GANSW has been asked to provide comments on SSD 10285. Please refer to the design review advice below for items that require further resolution:

**GOVERNMENT
ARCHITECT
NEW SOUTH WALES**

ROOF PLAN

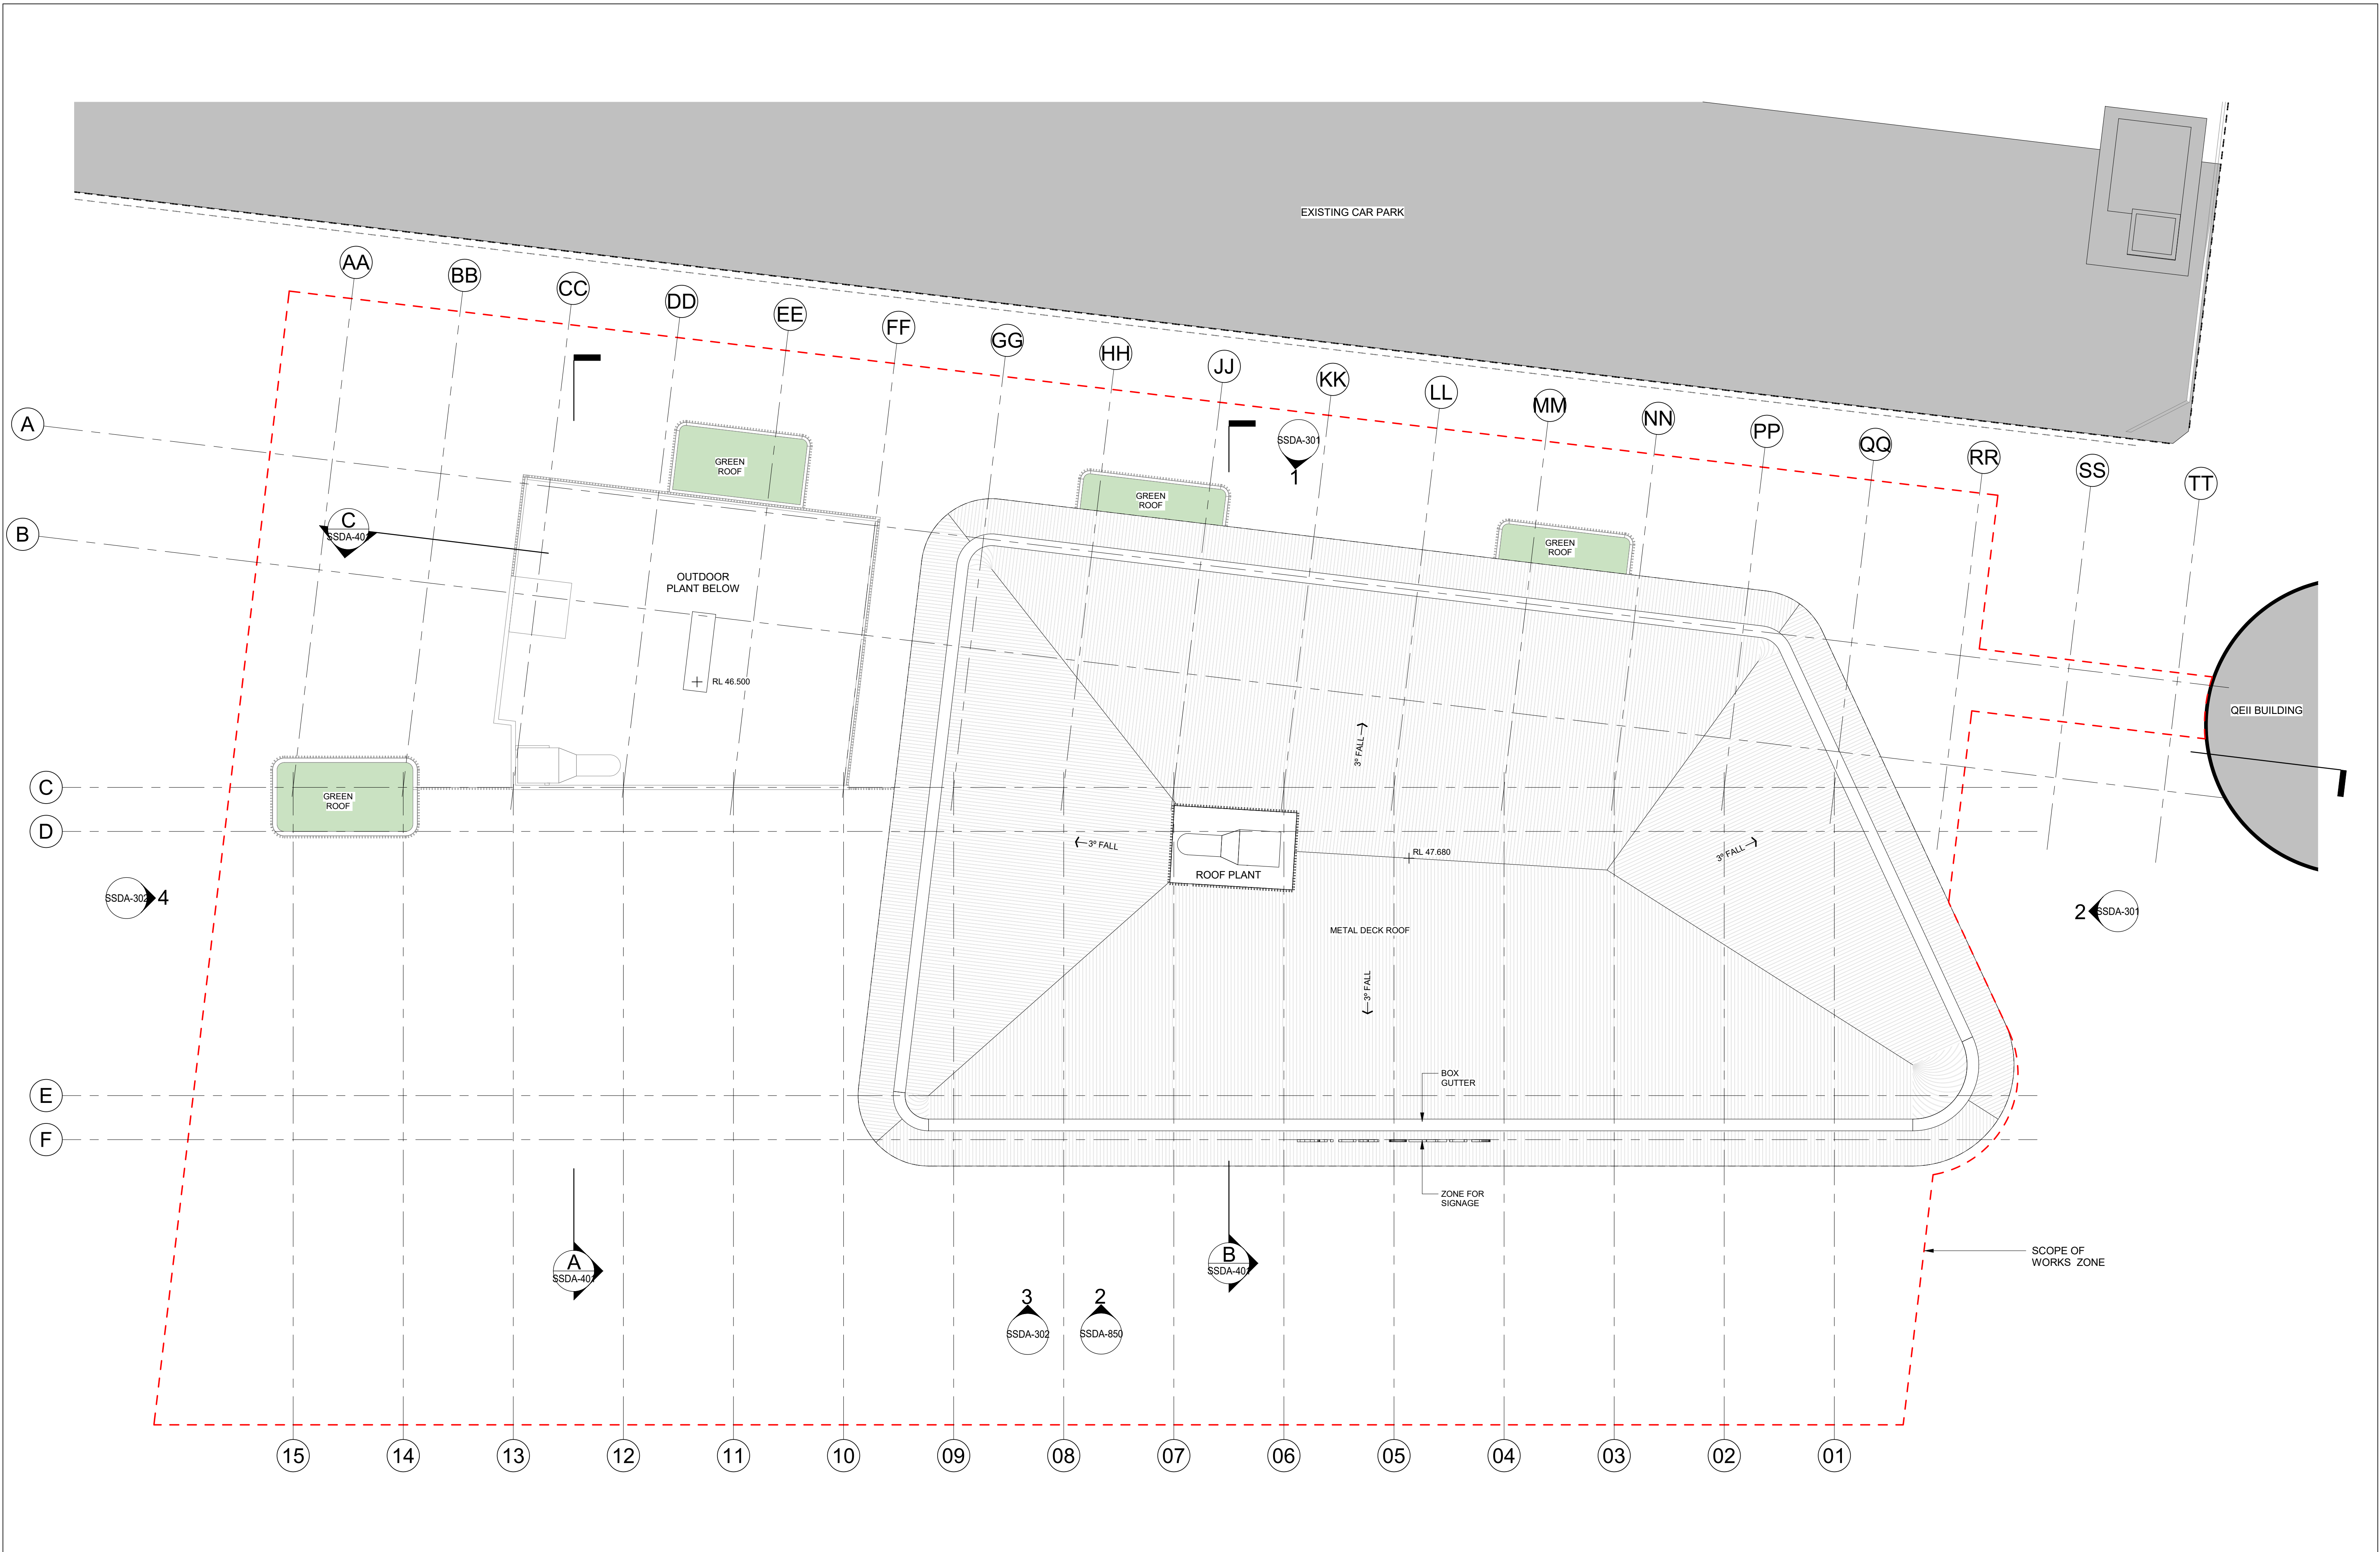
- Recommendation is made to incorporate a green roof and/or solar panels into the scheme.
- Provide details of acoustic mitigation measures for neighbouring residents on race days and during special events, particularly outside daylight hours (particular attention should be given to properties on Doncaster Avenue between Ascot and Darling streets)
